June 23, 2015

Ms. Nell Donaldson, Planner
and Planning Board Members
City of Portland
389 Congress Street
Portland, Maine 04101

RE: 72 Bishop Street

The following documentation and supporting information have been prepared in response to staff review comments received on June 4, 2015 responses are in **Italic**.

**BOUNDARY & TOPOGRAPHIC SURVEY**  
 AT  
 72 BISHOP STREET, PORTLAND, MAINE  
 MADE FOR  
**AVESTA HOUSING**  
 307 CUMBERLAND AVENUE, PORTLAND, MAINE

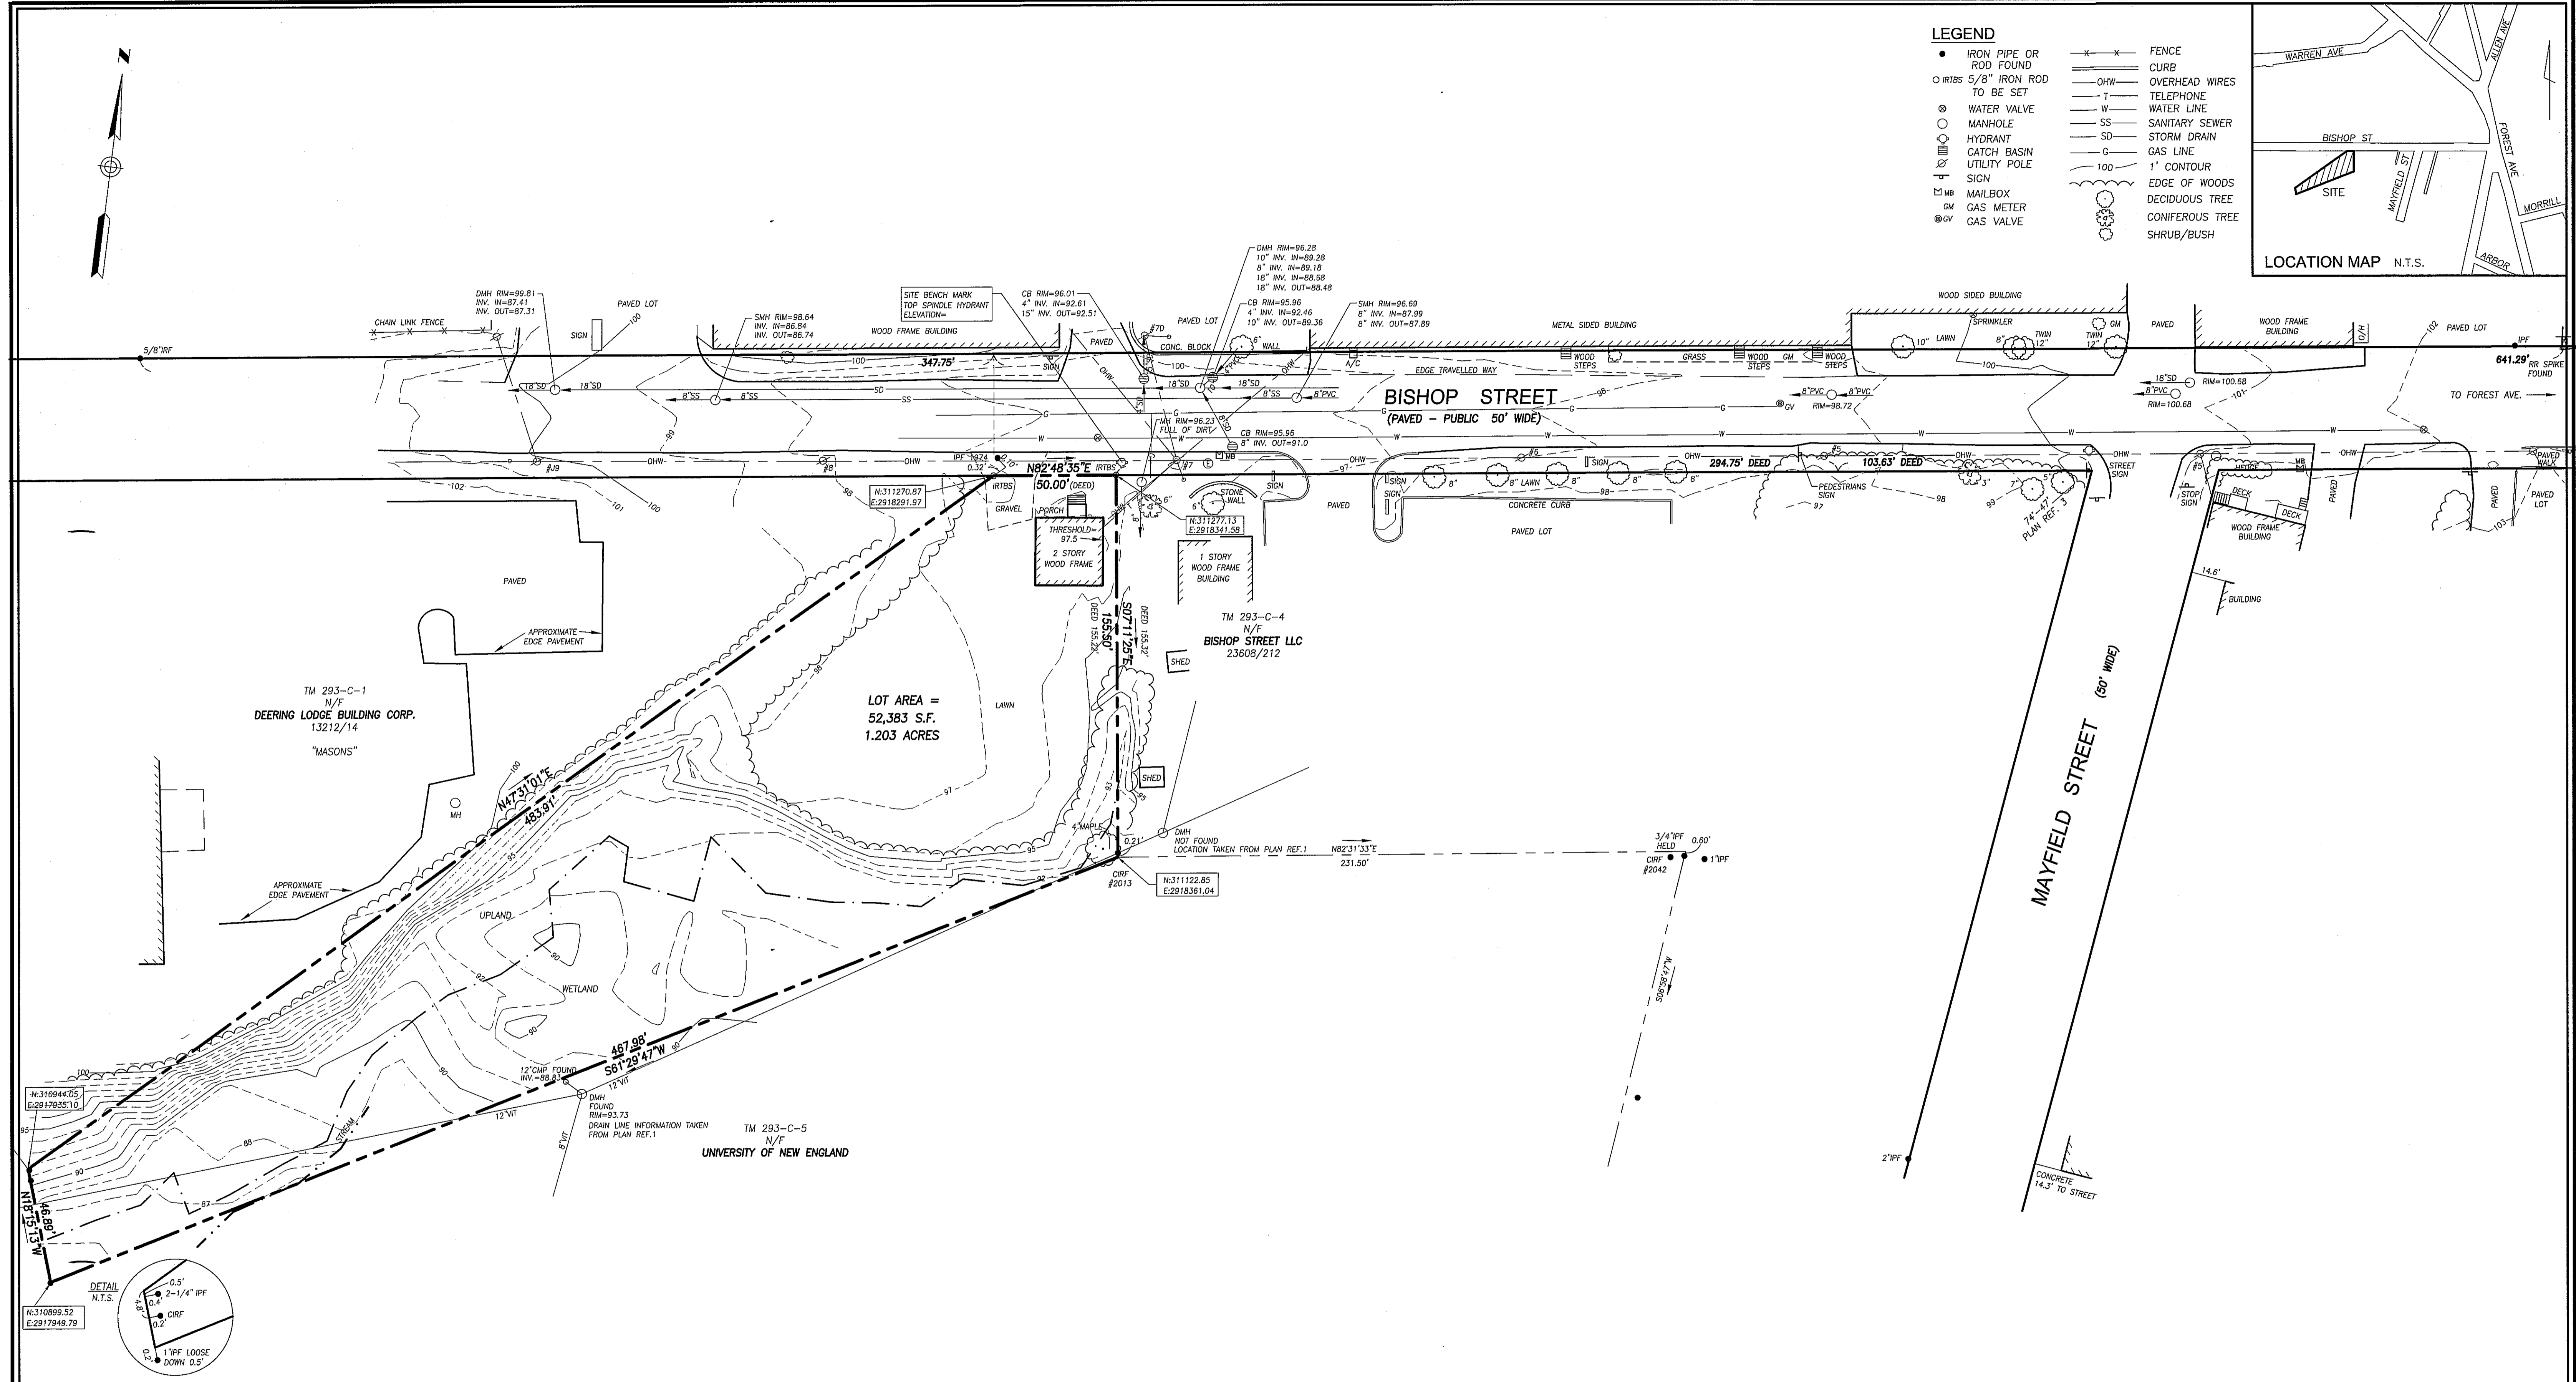
4. Site Benchmark: DPS Engineering does not use the top of hydrant spindles as benchmarks. Please use the bonnet bolt over the main hydrant connection.

The benchmark shall be revised as requested. The surveyor is currently updating the survey to address all of Mr. Clark's comments.

A5 FIRST FLOOR MECHANICAL PLAN
SCALE: 3/16" = 1'-0"

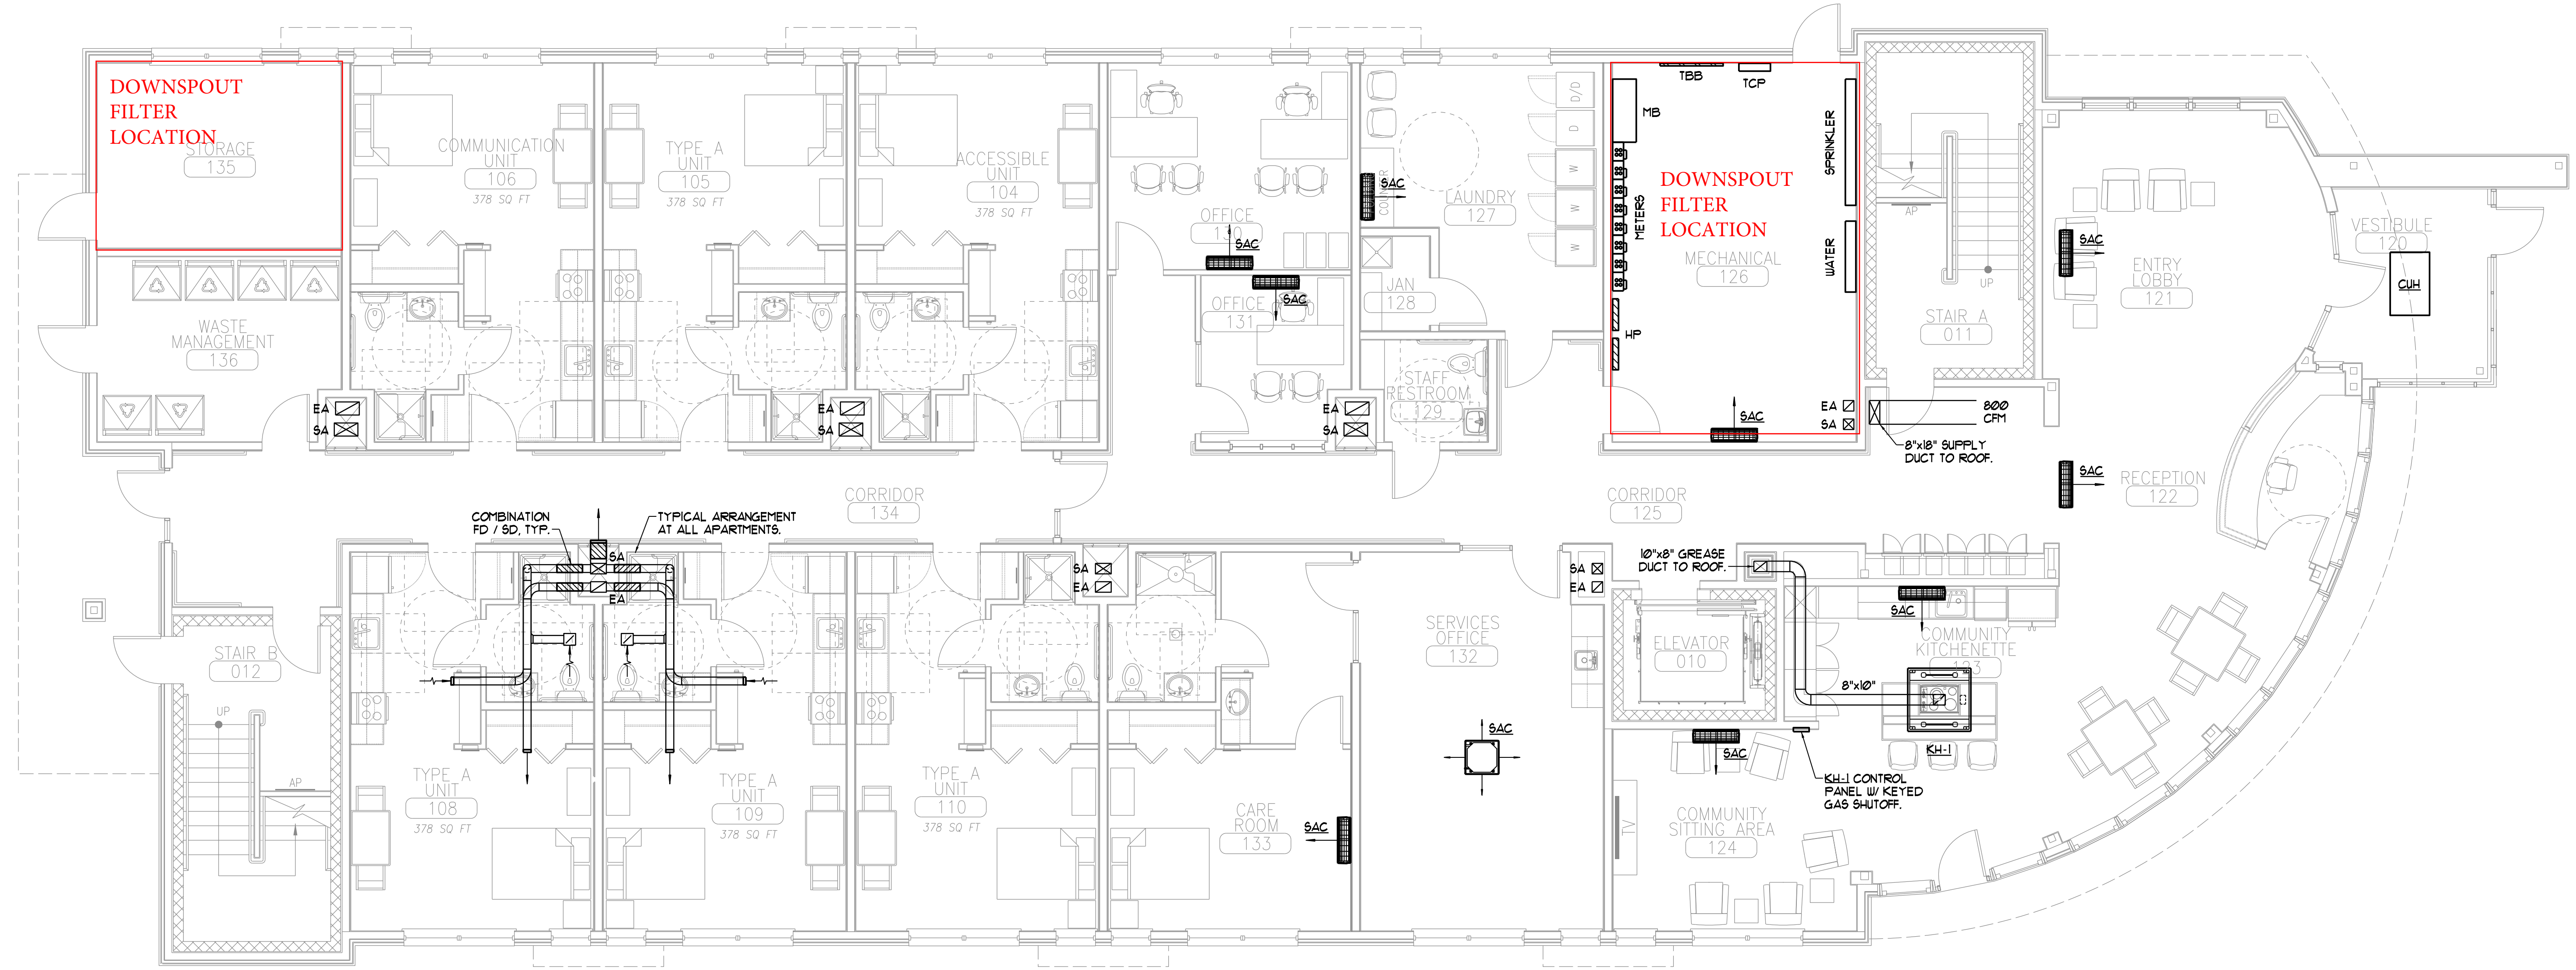
- (6bi) In-line roof drain filters

The manufacture information is included in this submission. Two filter locations are identified Sheet M1.01, First Floor Mechanical Plan. Note: treatment of roof area is being provided to exceed treatment required for an urban impaired stream.

Title: SUBDIVISION PLAT PLAN

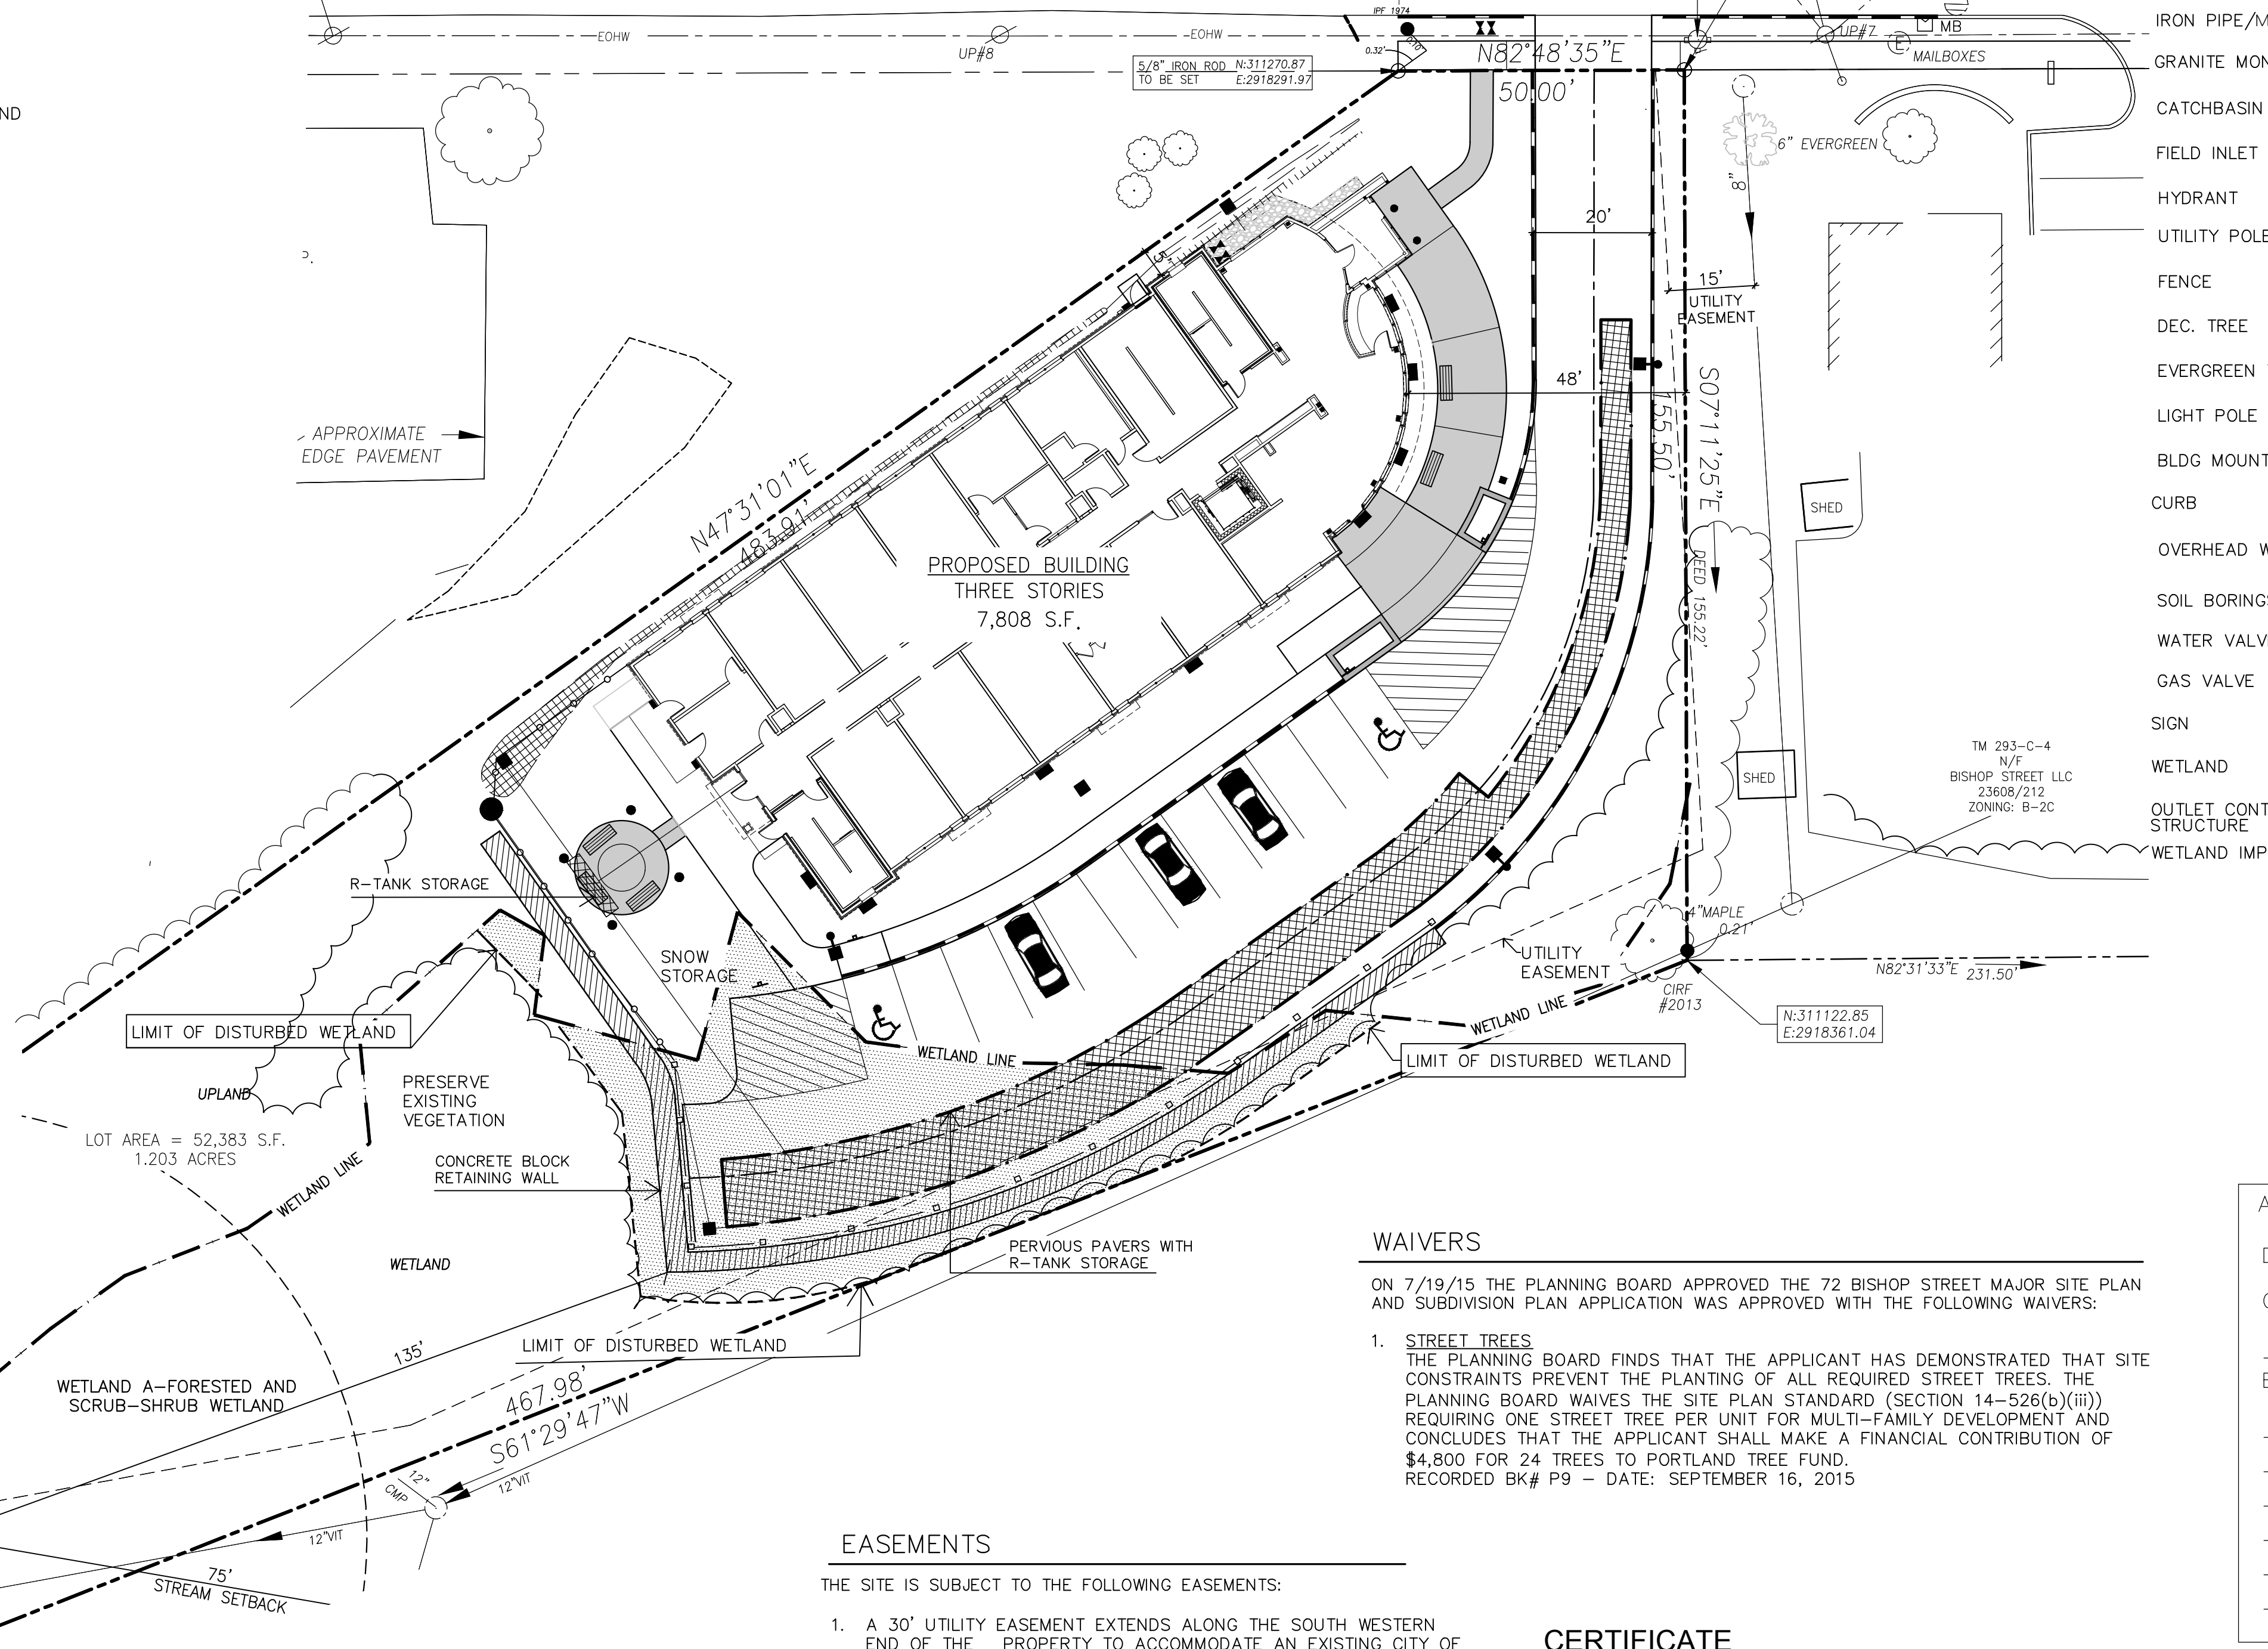
3. The limit of disturbed wetland line and associated notes should appear on the plat plan.

4. Snow Removal

The disturbed wetland line and associated notes have been added to the plat plan.

Note 22 has been added to the plat plan (Sheet 2A) stating that snow shall not be stored or dumped in wetland areas.
